Another easement

William Scott <wgs@portlandmaine.gov>
To: Helen Donaldson <hcd@portlandmaine.gov>
Cc: Charles Wordell <cww@portlandmaine.gov>

Thu, Jul 20, 2017 at 1:41 PM

EASEMENTS AND  
BUILDING SETBACKS PLAN

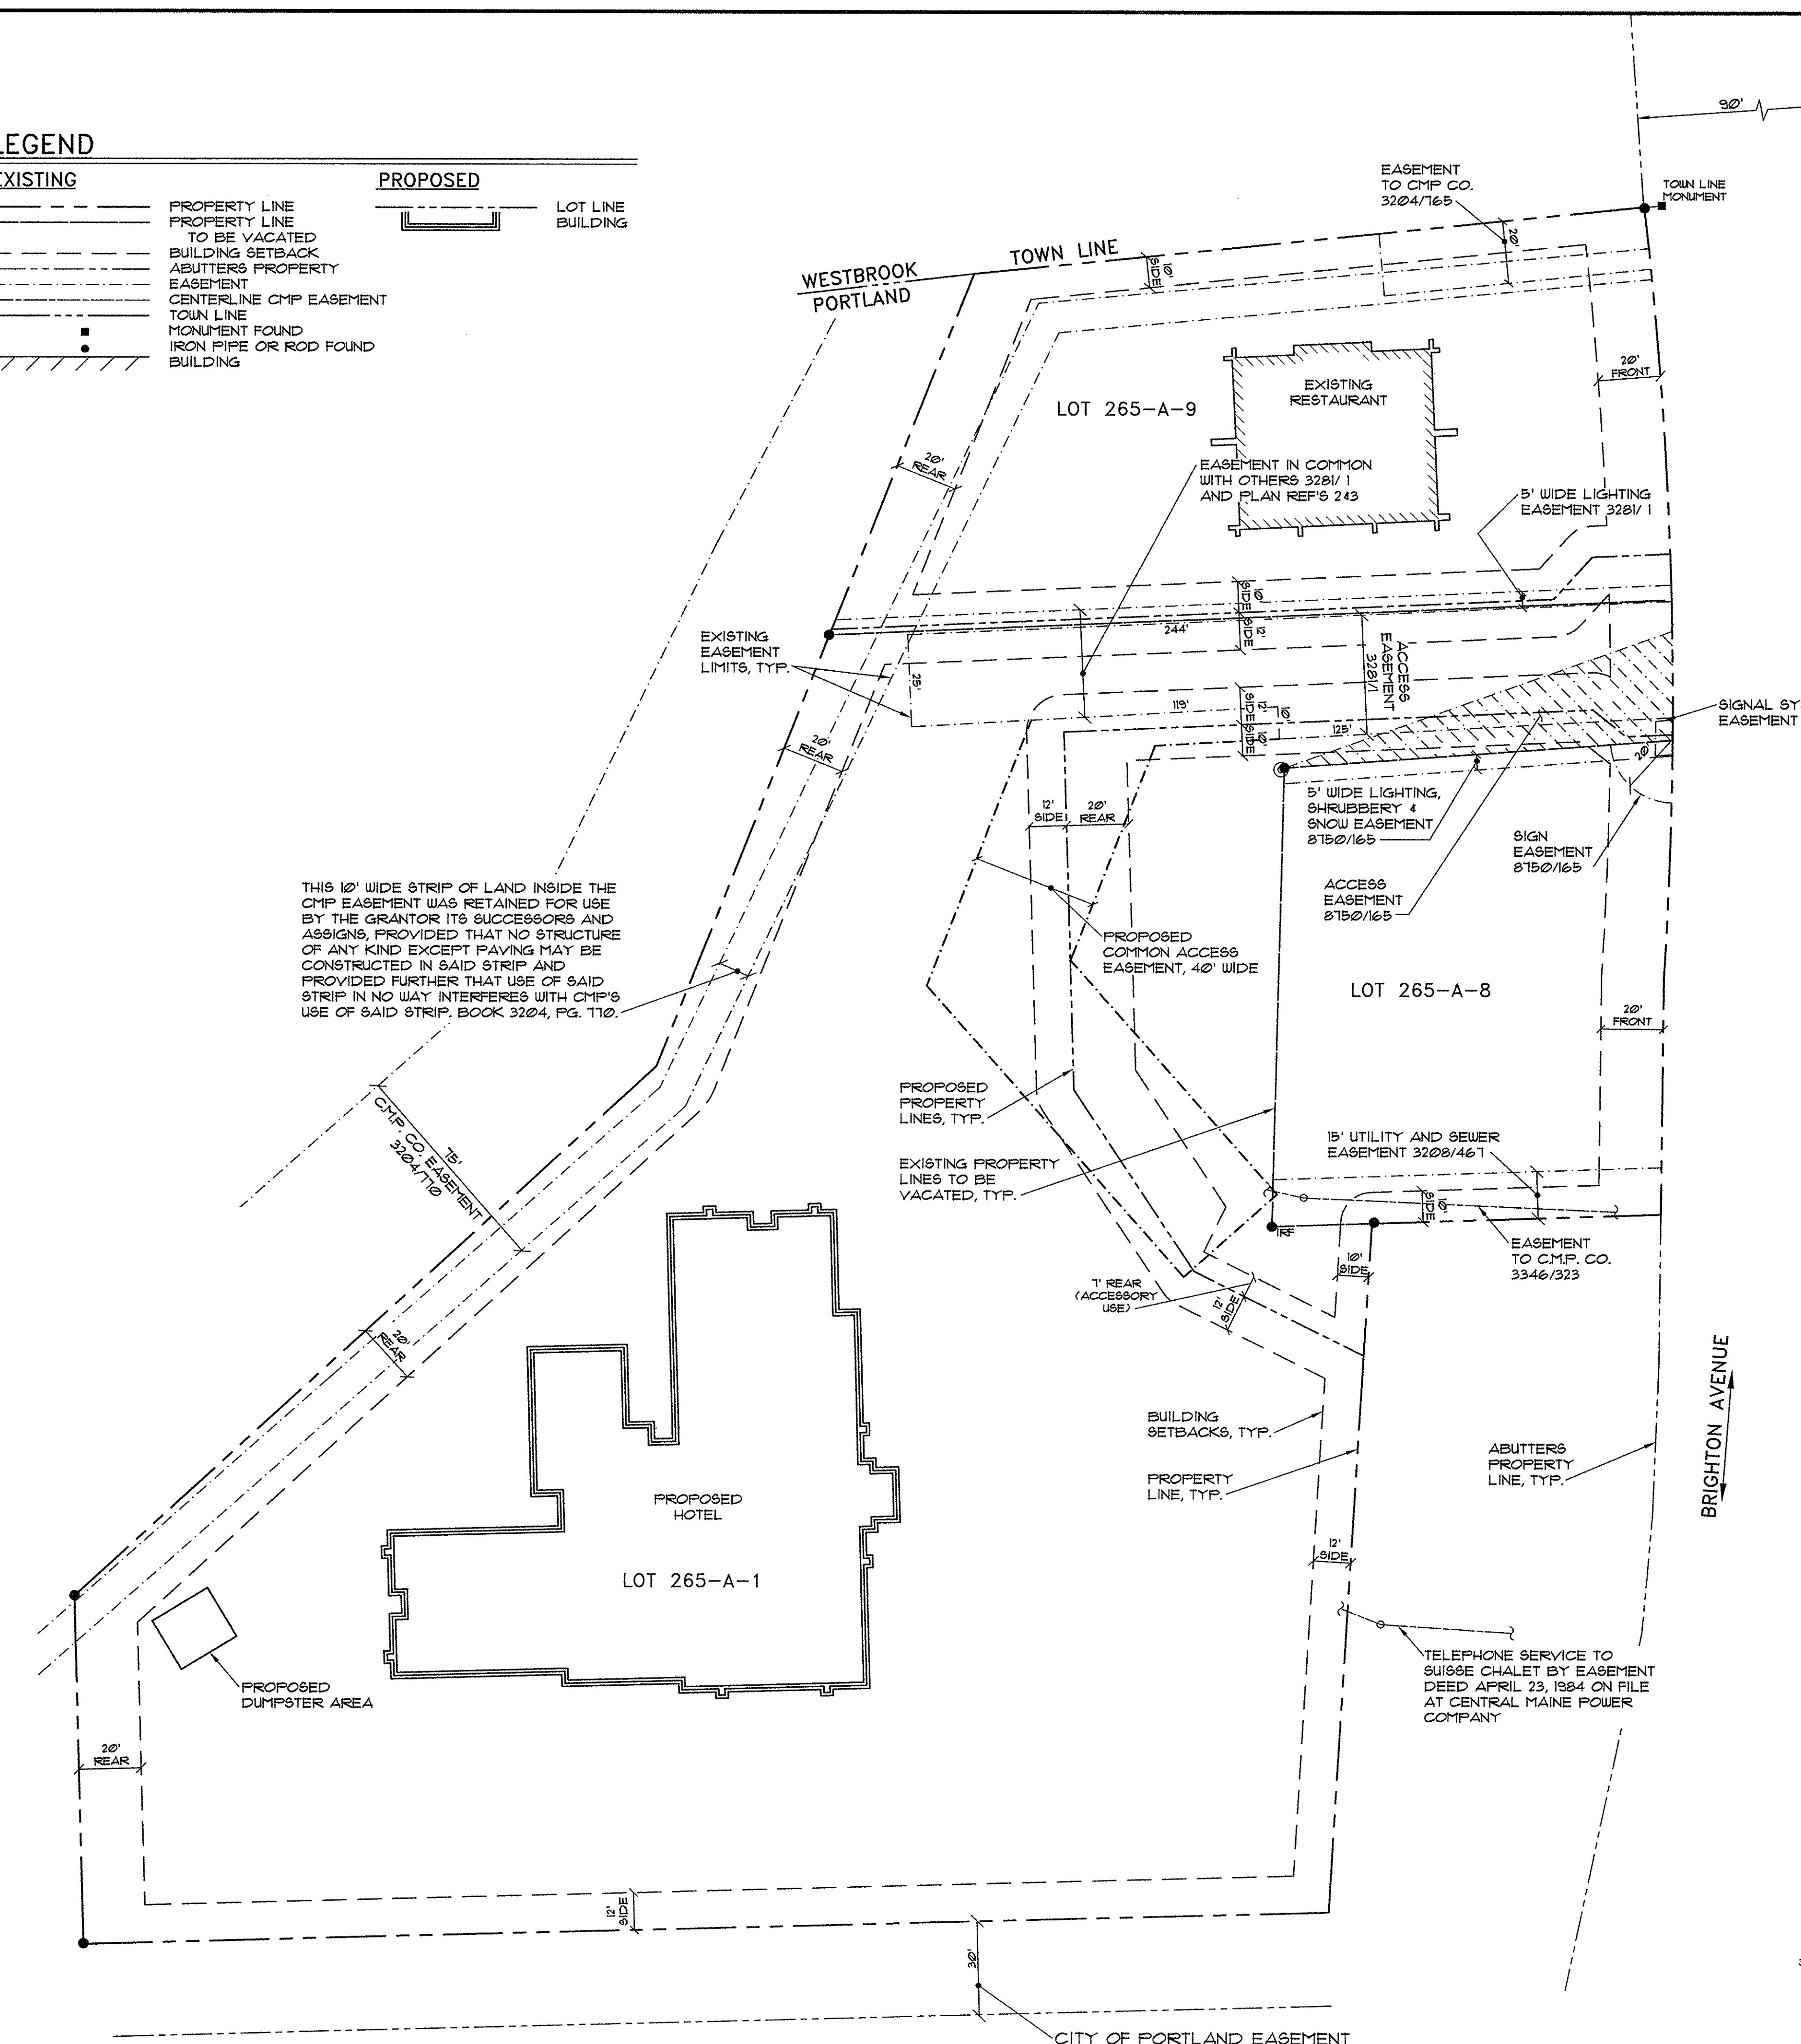
1. Label Brighton Avenue;
2. Label the Town Line, and label which side is Portland and which side is Westbrook;
3. Label the Boundary Line (can't assume it's the same as the Town Line);
4. Label the locus property owner and the abutting property owner;
5. Add "Magnetic (year)", "True" or "Grid" to the North Arrow, whichever is appropriate;
6. Add a description of the Iron marker and Monument shown on the Exhibit;
7. Not sure this Exhibit needs that long note about the 10 foot wide strip of land inside the CMP easement.
